MONA OFFSHORE WIND PROJECT

Response to Rebecca Face D6 Submission

Application Reference: EN010137

Document Reference: S_D7_22

Figure 1

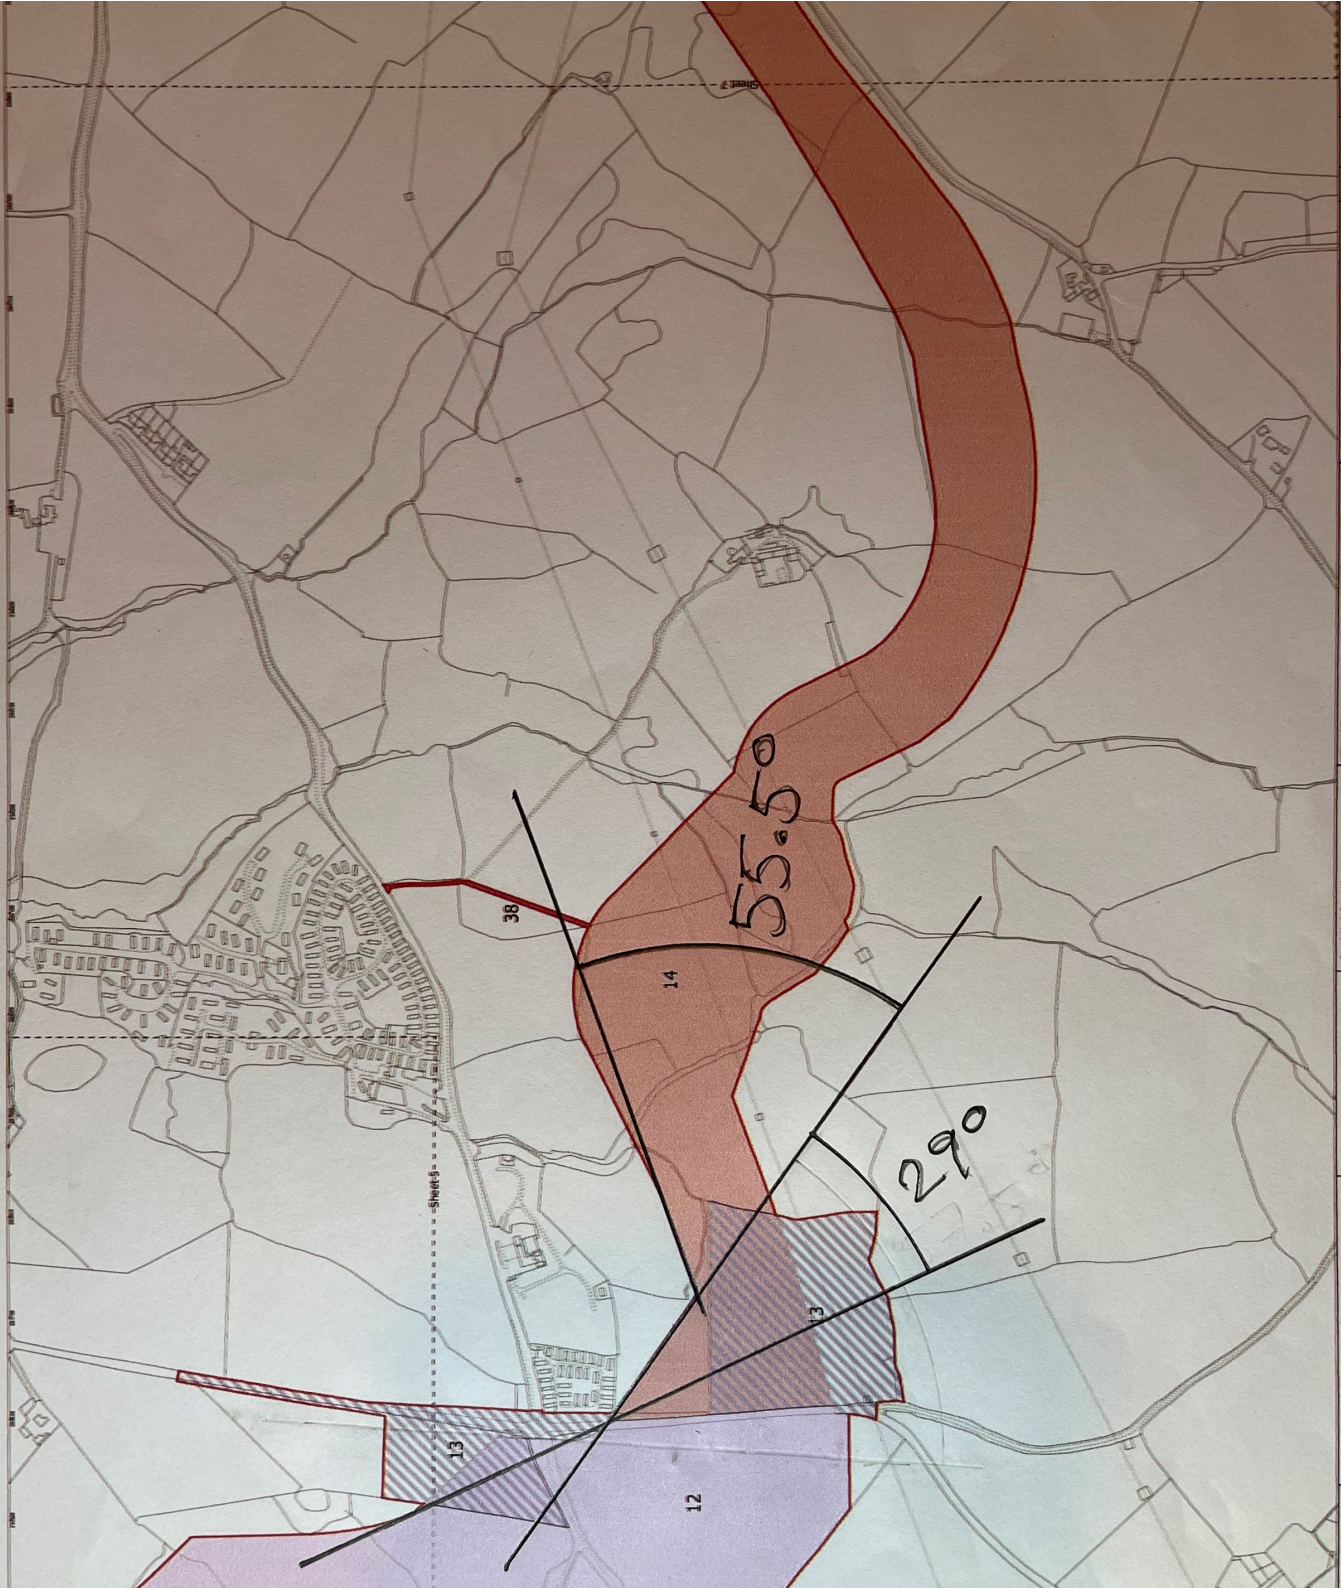
REP6-150.14	During my discussions with the applicant, the only reason they have ever given me for the extra width that they're asking for at this location, is that they want to avoid a "hard bend". The angles of turn between TCC2 and TCC3 are 29 degrees and 55.5 degrees (see picture 3). This is a very gentle sweeping curve which will not be altered by reducing the width of the corridor. This is in comparison to a 96.5 degree bend followed by a 68 degree bend on works plan onshore sheet 10, (see picture 4) and an 100

heavy load mover 4.5m wide load bed

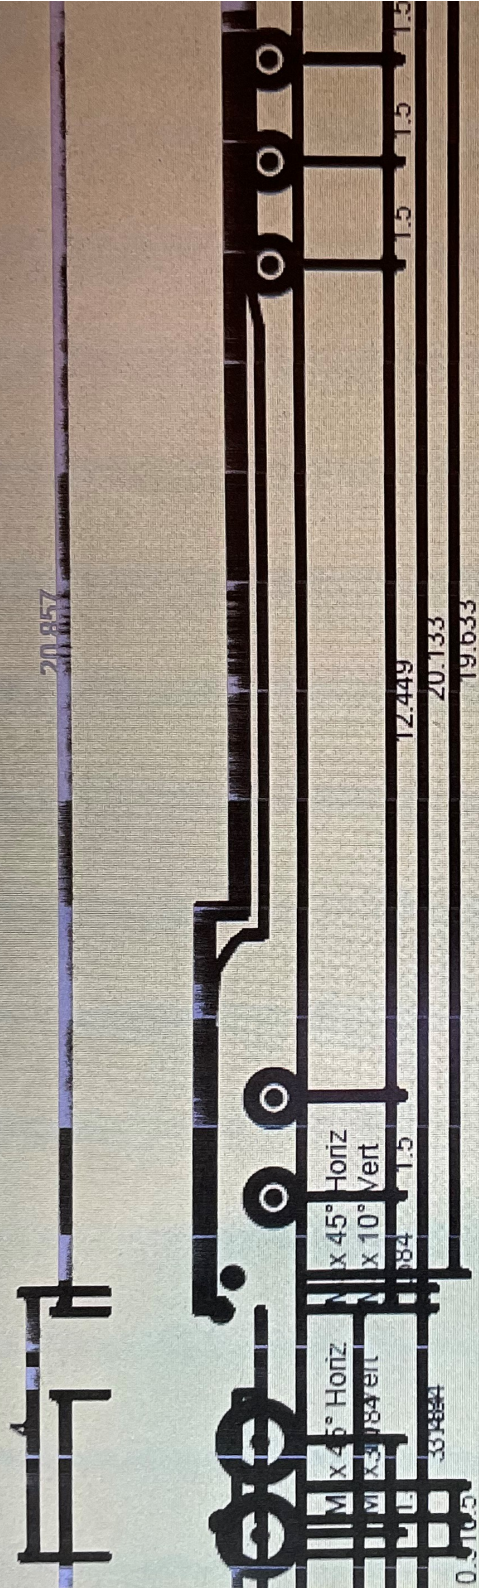
<p>REP6-150.17</p>	<p>The third biggest concern is the access gateway into TCC2. The simple fact of this issue is that the applicants cable delivery truck will NOT fit through the gate. The specification of this truck is an astonishing 28.816 meters long by 4.5 meters wide, (see picture 6). The gateway is 61 meters down the road, past a choke point, with an 85 cm high verge on the opposite side. To facilitate this truck getting through this gateway would require the complete removal of the verge and trees on the opposite side, or the expansion of the bell mouth to such an extent that there will be no safe separation from the A548, and the removal of 30+ meters of bat feeding hedge. The drawings and descriptions in the application are hopelessly inaccurate.</p>	<p>A preliminary access design layout for TCC2 is shown at Appendix D of the Outline Highways Access Management Plan (OHAMP) (J26.16 F03) and has been designed in accordance with highway design standards to allow for all construction vehicles to safely turn through it. Swept path analyses are contained therein of HGVs turning through TCC2 such that both arriving and departing HGVs can do so simultaneously and the geometries of TCC2 are such to enable these movements safely.</p> <p>Such geometries for TCC2 allows for the movement of cable drum vehicles to also turn both in and out of the access. Knowledge and professional judgement on vehicle turning requirements defined this, however, to demonstrate the ability of the cable drum vehicle to arrive and depart through TCC2, a swept path analysis is attached at Annex 1.</p> <p>This demonstrates the ability of the cable drum vehicle to satisfactorily arrive and depart between the A548 Penrefail Crossroads and TCC2. It shows that the cable drum vehicle would do so without any overrun of the verges (the cable drum vehicle would remain within</p>
